From: Carol Reynolds
Sent: 28 June 2017 14:34
To: Planning.Responses
Cc: Anita Gardner
Subject: FW: Planning Consultation on: R/78/17/PL

APPLICATION R/78/17/PL

Site Address: 137 The Street Rustington BN16 3BN

Description of Works: Change of use from shop (A1 Shops) to restaurant/cafe (A3 Restaurants/Cafes) with elevational alterations & outside seating.

PROPOSED - NORTH ELEVATION 1:100

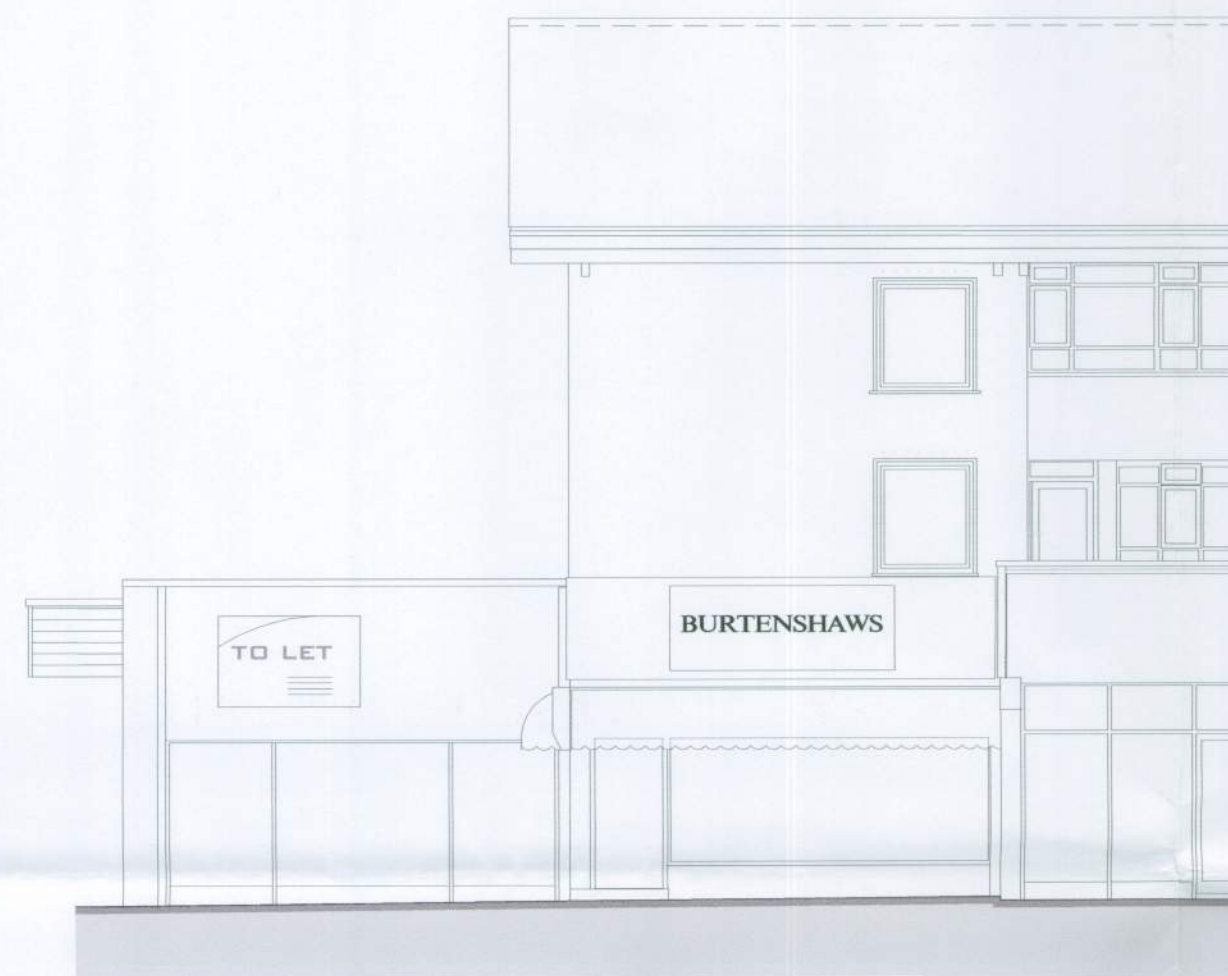
*Bi fold windows to be closed by 21:00 hours

FLOOR / SITE PLAN 1:100

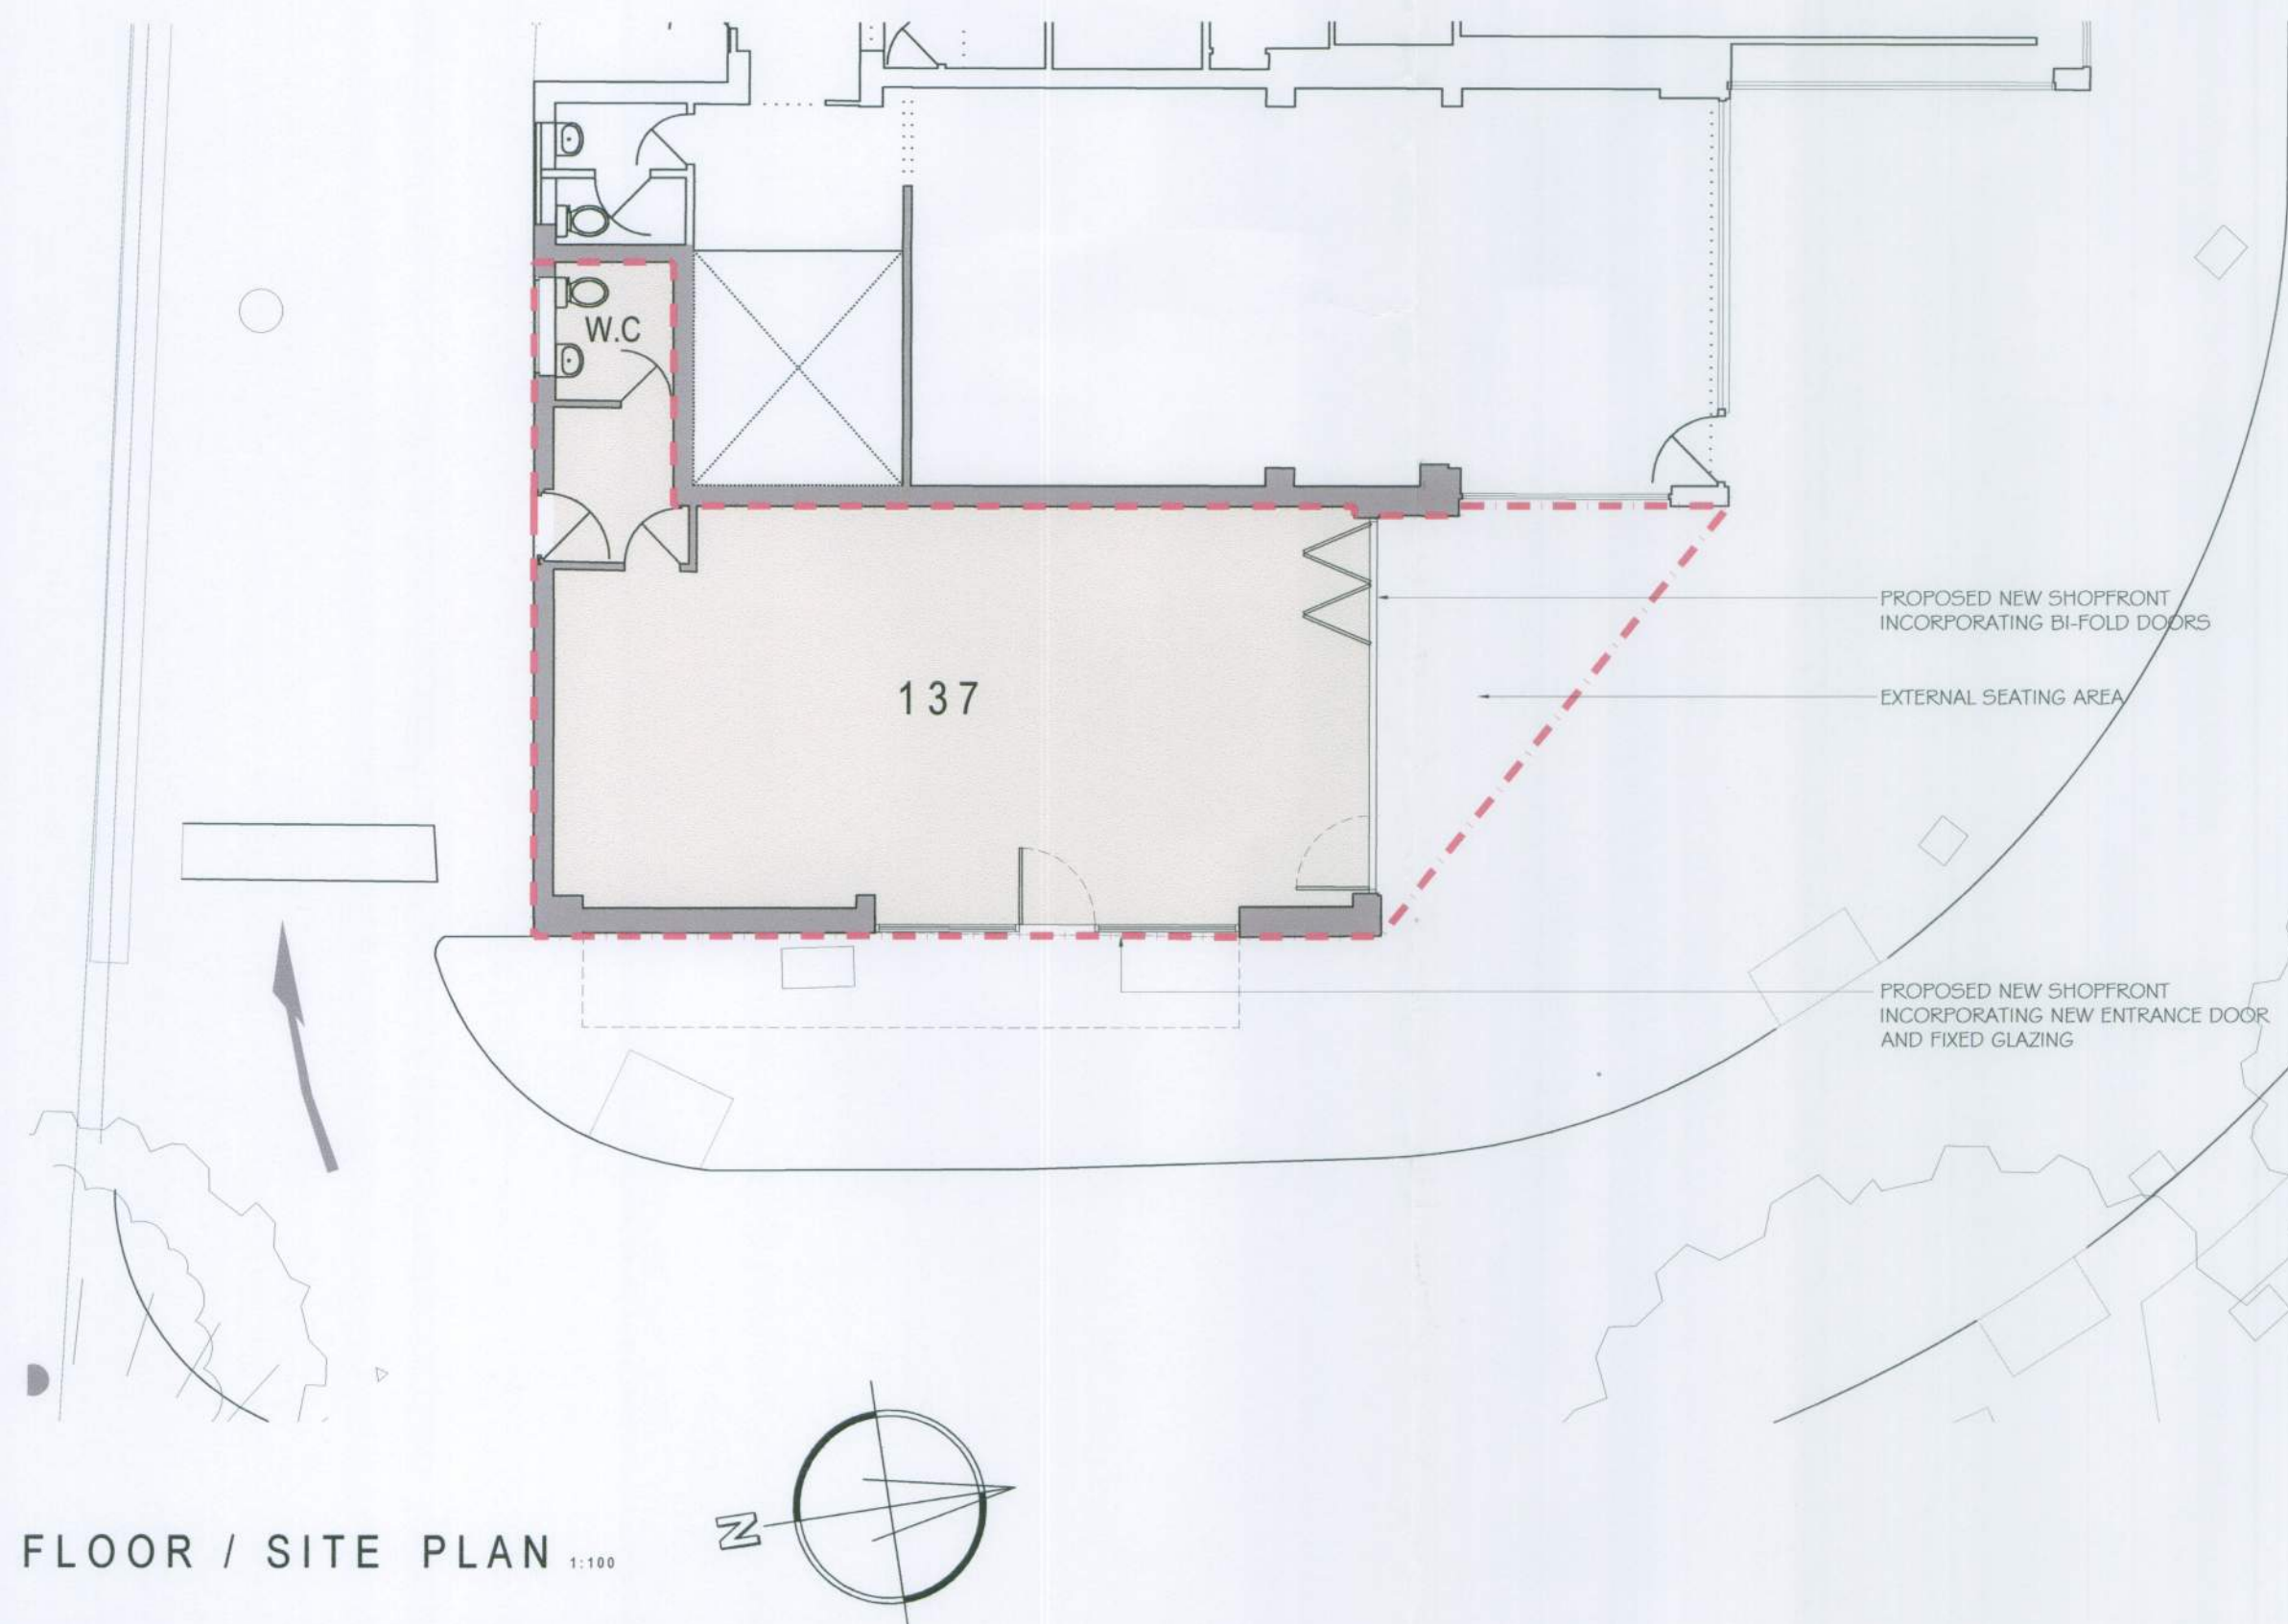
4.It is considered that the use of any outside space for drinking/dining, will introduce an uncontrollable noise source in respect of nearby residential units. As a result it is important to ensure control of the potential for noise disturbance at the Planning stage. I would suggest the following conditions:

*No music to be permitted outside at any time

*The outside area shall not be used for consumption of food, or drink after 21:00 hrs and the outside area to be to be closed by 21:00 hrs.

*Tables and chairs to the outside to be put away by 21.30 to discourage people from gathering here.

Sanitary Accommodation. The described provision of one male WC and one female WC, both with separate wash hand basins, will be sufficient for up to and including 50 customers to include any *al fresco* dining area. Given size limitations then this provision will be also be acceptable as staff sanitary accommodation. One of these WC units should be wheelchair accessible. (See Arun District Council 'Provision of Sanitary Accommodation in Food Business')
